Our Reference: OUT11/981

**Response to Submissions
Proposed Dargues Reef Gold Project**

I refer to your email dated 13 January 2011 seeking comments from Industry and Investment NSW (I&I NSW) regarding responses provided by Big Island Mining Pty Ltd, a wholly owned subsidiary of Cortona Resources Limited, on the submission made by this Department on the Environment Assessment (EA) for the proposed Dargues Reef Gold Project.

APPENDIX 3 INDICATIVE FINAL LANDFORM

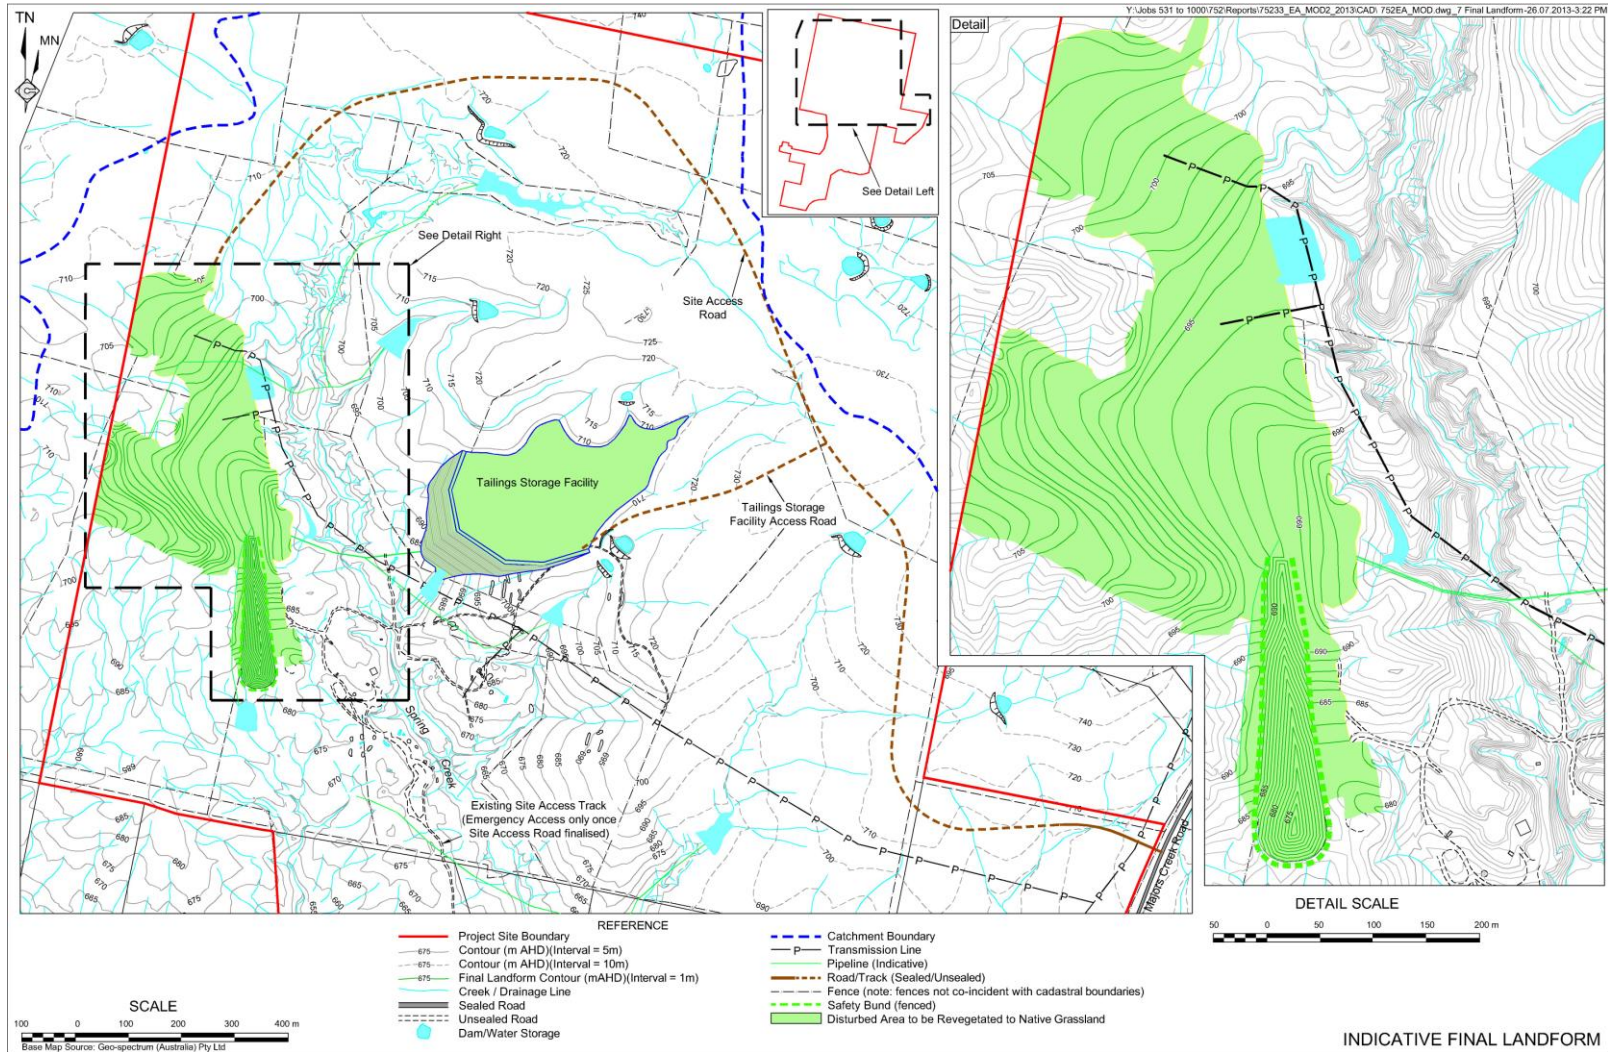
The Department's initial comments "***The retention of the box-cut in the final landform is not supported by I&I NSW...***" is valid as I&I NSW still maintains that it is not consistent with the proposed final land-use and it will require ongoing maintenance.

Bunding and fencing has previously been used at several mines but ultimately leaves a site which requires ongoing maintenance and still leaves a potential safety risk. Retention of a remnant void is generally only supported when a positive future use for the void is identified. Historically, remnant voids have been left open, mostly for reasons of minimising costs. However, this is no longer seen as an acceptable outcome, in most instances.

I&I NSW does not believe that sufficient information have been provided to justify the proponent's claim. Further explanation is required. In particular, alternative final landforms, which require little or no importation of materials, possibly with a lower height and reduced slope angles, need to be considered.

The availability of fill material and the estimated costs for import and emplacement of this material needs to be investigated.

I&I NSW retains its view that that the filling of the box cut is the most suitable final rehabilitation outcome, removing safety risks and the need for ongoing maintenance.

Subject to the grant of project approval from the Department of Planning, and following the lodgement of a mining operations plan, I&I NSW will seek a security deposit sufficient to enable the filling of the box cut until such time as an alternative rehabilitation outcome has been formally agreed
